From: Dave Norris <norrilyn@gmail.com>
To: <plan_comment@planning.nsw.gov.au>
Date: 25/01/2012 3:49 pm
Subject: Re: Submission KINGS FOREST Stage 1 Subdivision and Bulk Earthworks - Application No. 08_0194
Attachments: Submission.doc

Re: KINGS FOREST Stage 1 Subdivision and Bulk Earthworks - Application No. 08_0194

Submission to Project Application 08-0194 □Kings Forest
Stage 1 Subdivision and Bulk Earthworks

Annette McKinley and David Milledge
25 January 2012

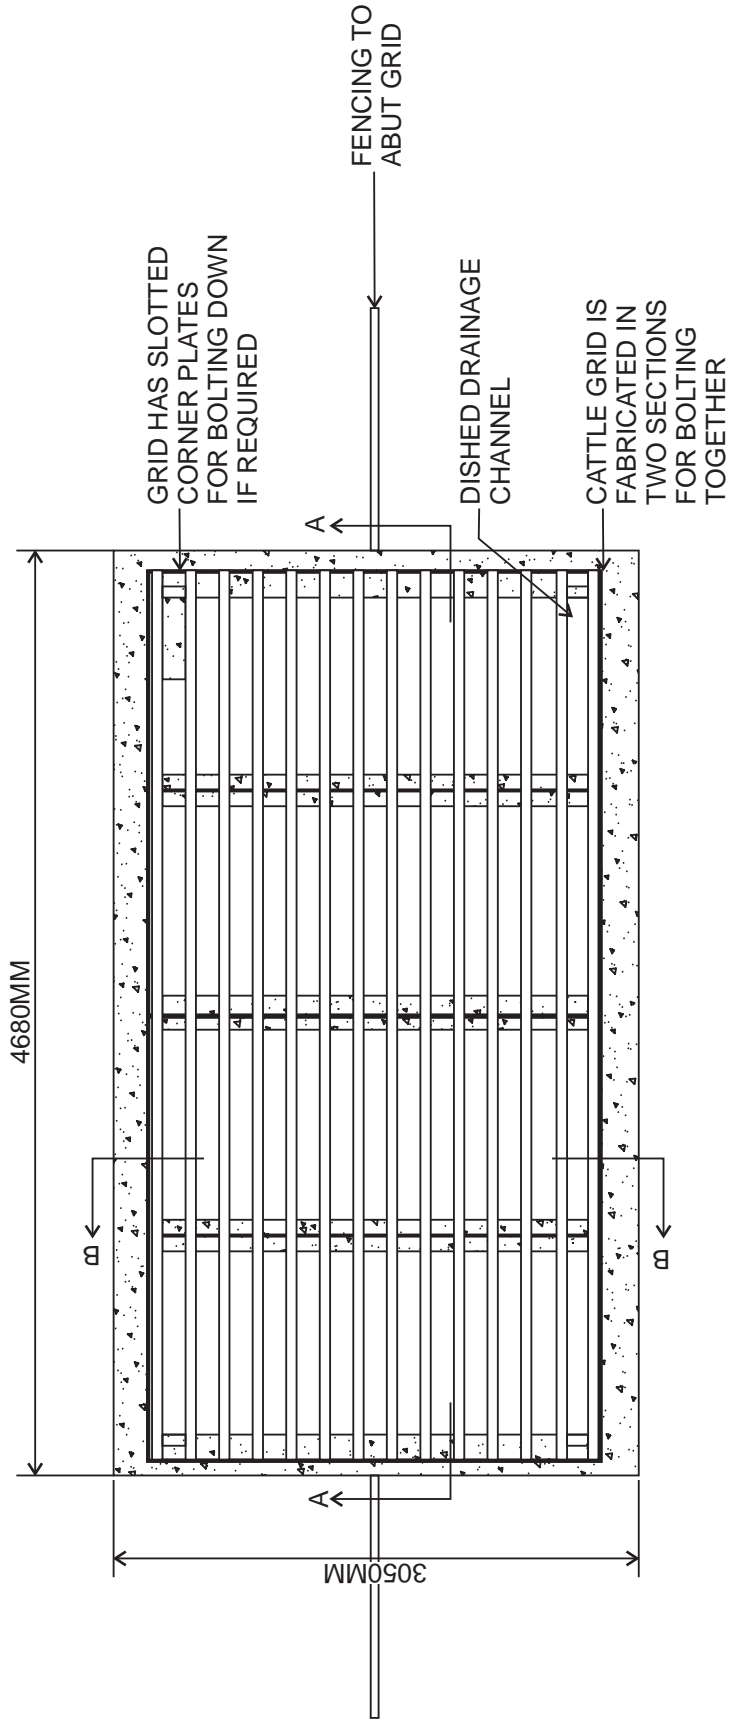
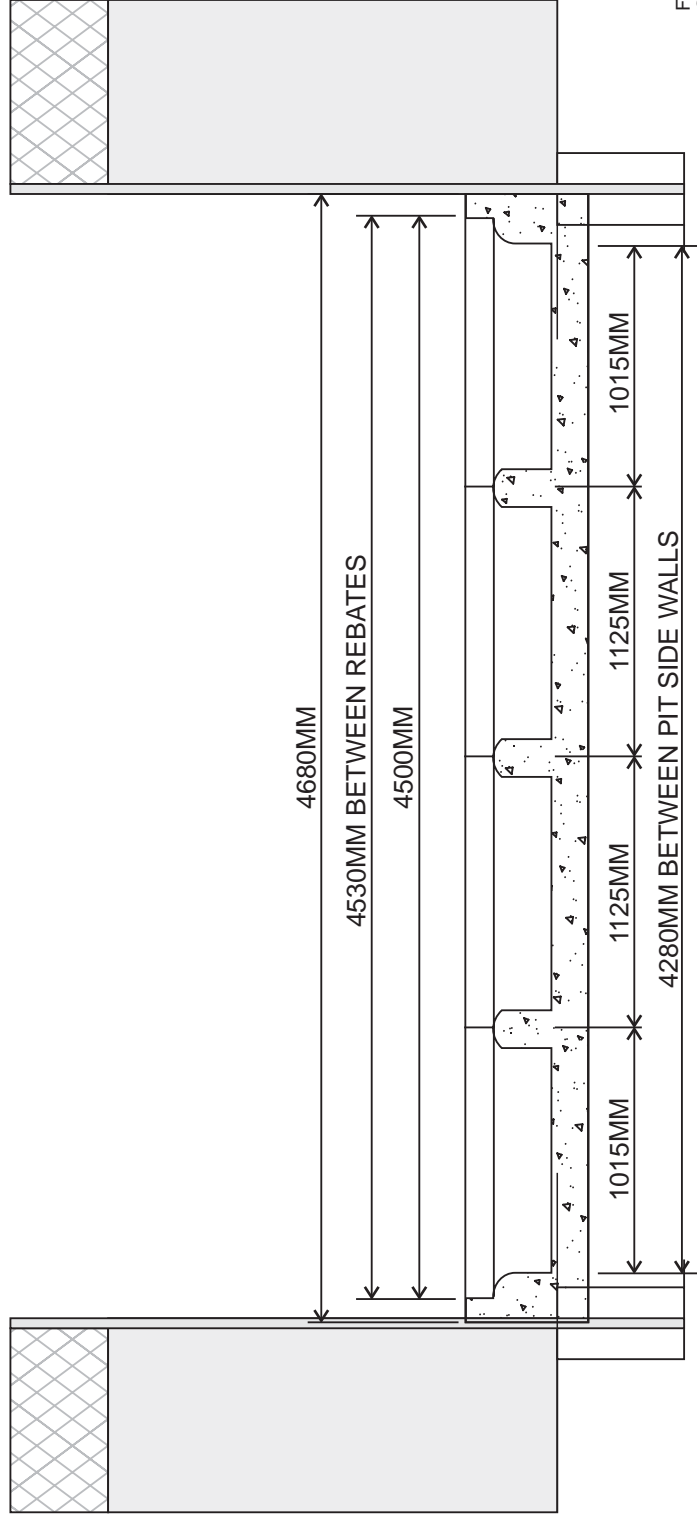
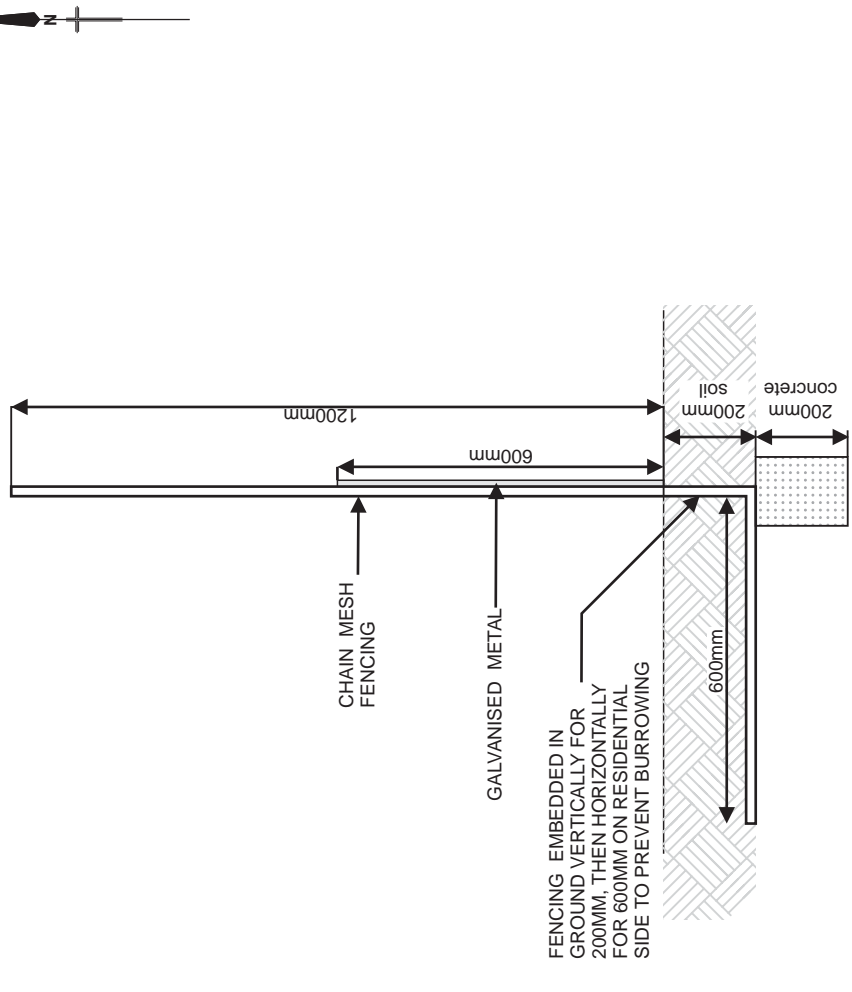
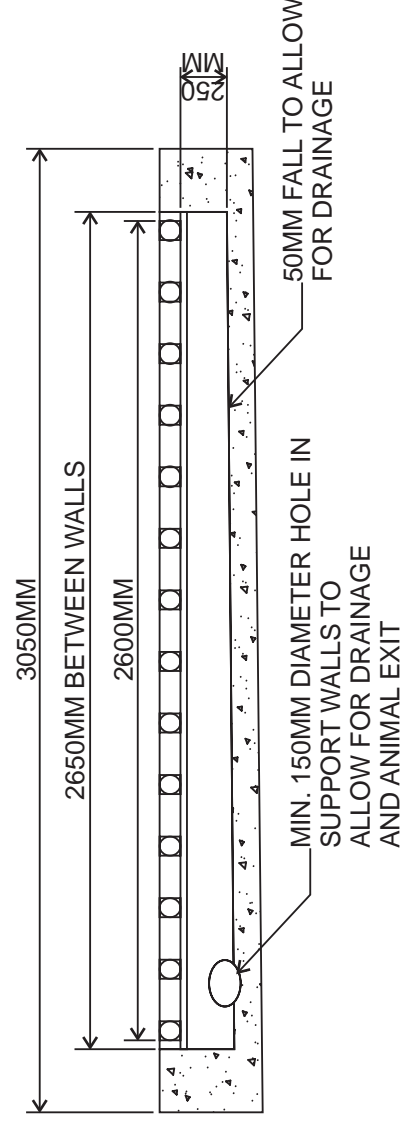
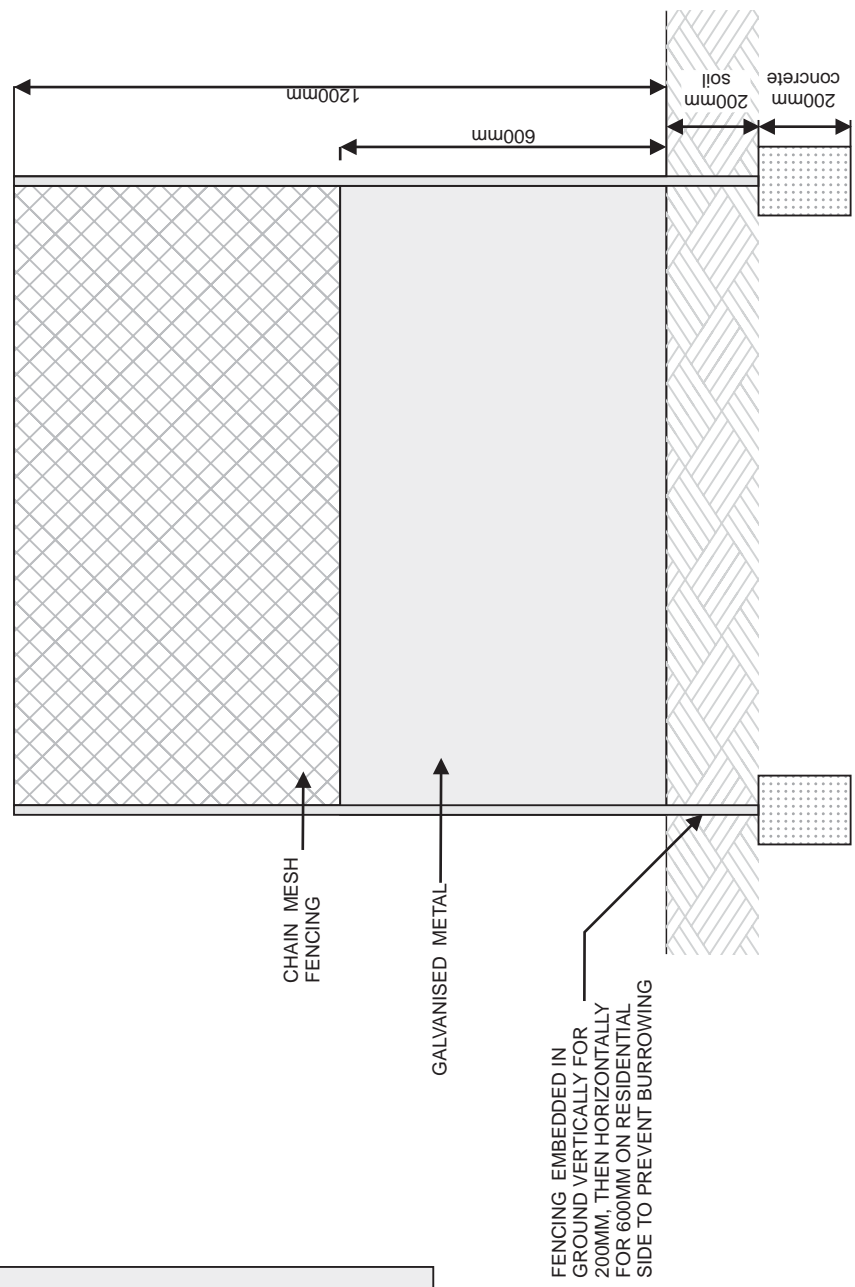
Similarly, ongoing monitoring and maintenance of Koala fencing, underpasses and grids is essential. The KPOM refers to the Koala fencing for the Skyline Road Upgrade in Lismore Shire (Section 9.6). This fence was partially collapsed when viewed in mid 2011. Unfortunately, Koala fencing has been inadequately maintained in areas of the north coast including Tweed Shire.

Although grids may deter Koalas they do not necessarily prevent dogs from entering an area. In addition the proposed fencing at Kings Forest is not high enough to prevent larger dogs from leaping over.

Monitoring should be undertaken on a minimum fortnightly basis and funding should be available so that maintenance can be carried out immediately a problem arises. If Tweed Council is to undertake this task it should be developer-funded on an on-going basis so that the Tweed ratepayer is not left footing the bill.
